Date: 14-Aug-2020
Our Ref: 2020/92431

**Application for Approval of Details Reserved by Condition
Town and Country Planning Act 1990
Planning (Listed Buildings and Conservation Areas) Act 1990**

**Discharge conditions 3, 4, 7 on previous permission 2019/91083 for demolition of
existing dwelling and erection of detached dwelling with detached garage/store
345, Bradley Road, Bradley, Huddersfield, HD2 1PR
Application Number: 2020/92431**

(Image of On-Site Sample)

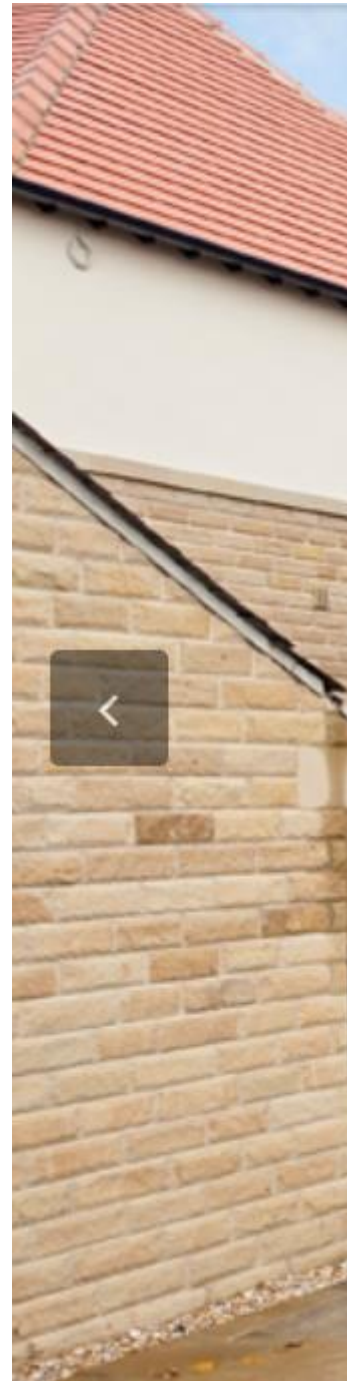
These materials are considered visually acceptable in the context of the street scape and
are approved for use.

Boundary Screens

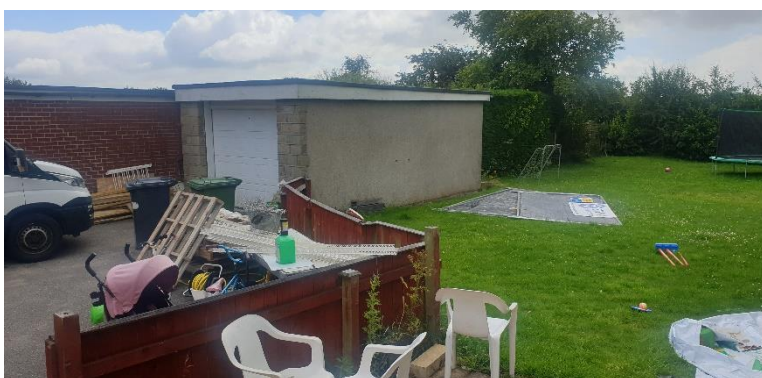
Although the fencing is generally acceptable, and would retain the privacy of residents of adjoining properties, I am concerned that the height of the fence close to the boundary with Bradley Road could hinder visibility for drivers leaving both nos. 343 and 345. This would not be in the interests of highway safety. Condition 7 cannot be discharged at this time.

Please provide further information/clarification regarding the height and location of the fencing to sam.jackman@kirklees.gov.uk and teresa.harlow@kirklees.gov.uk within 2 weeks of this letter quoting application no. 2020/92431.
